Department of Transportation

March 21, 2024

SH 083/MP 27.60
Town of Monument/EPC

RE: Special Use - Monument Glamping II

SITE PLAN

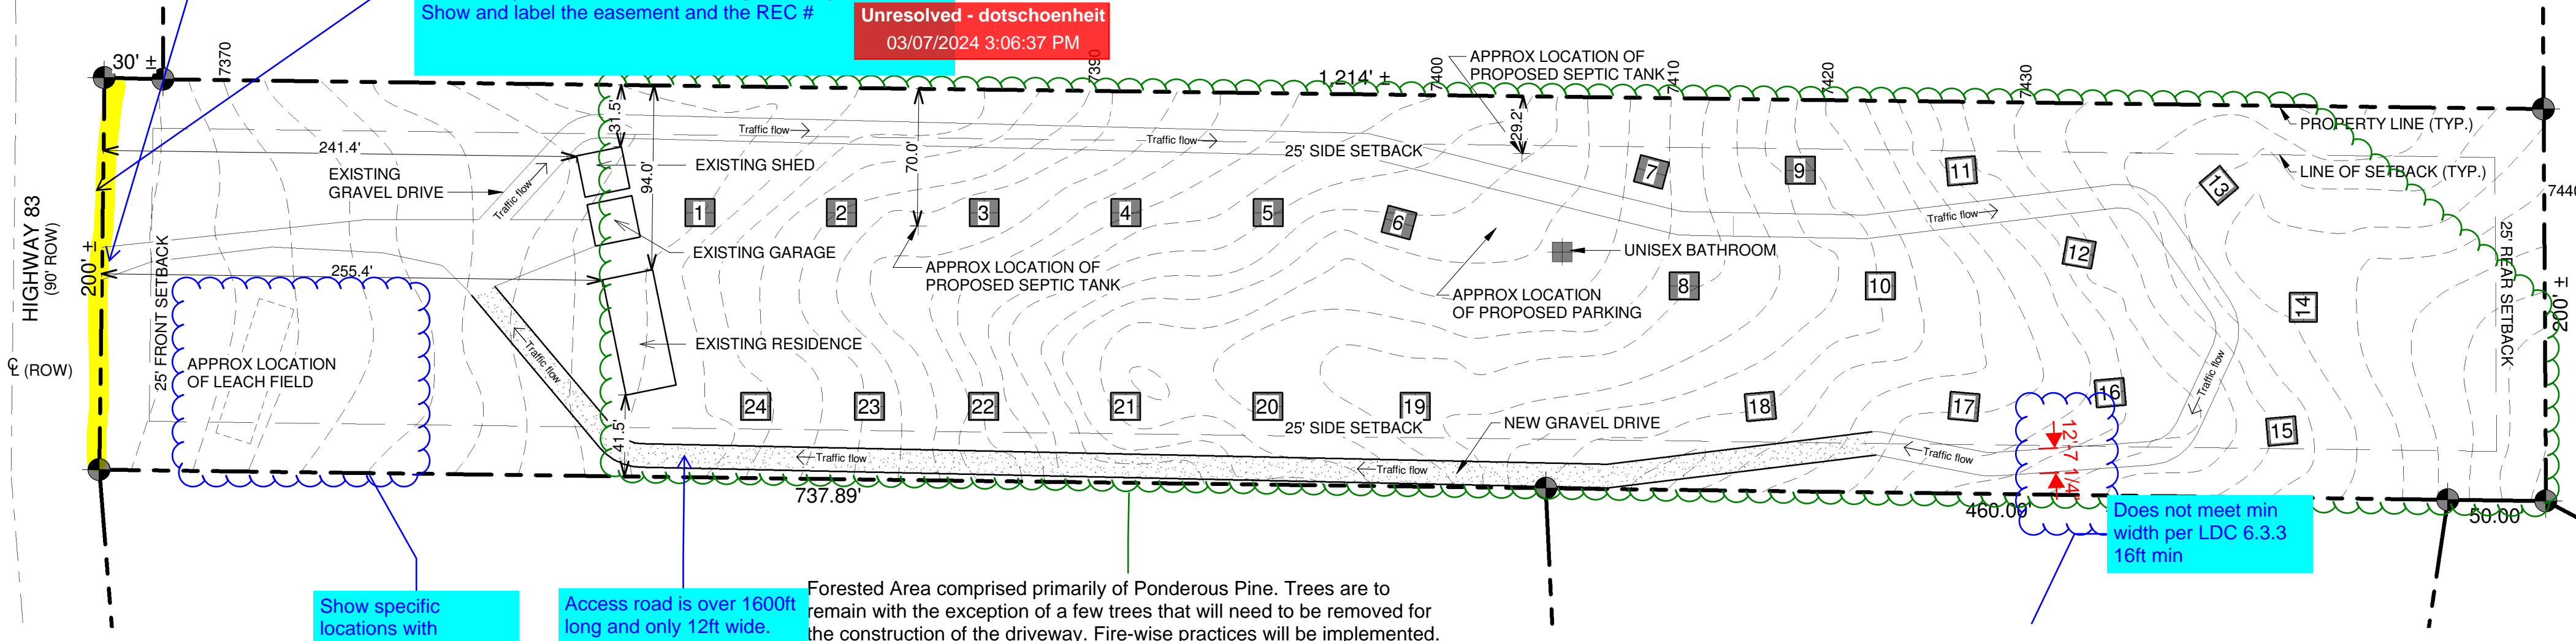
- Site Plan:
 - 30-foot access easement label not clear that the easement is across entire lot
 - Include 20 or 50-foot hard surface (20-feet if 12 units, 50-feet if 24 units).
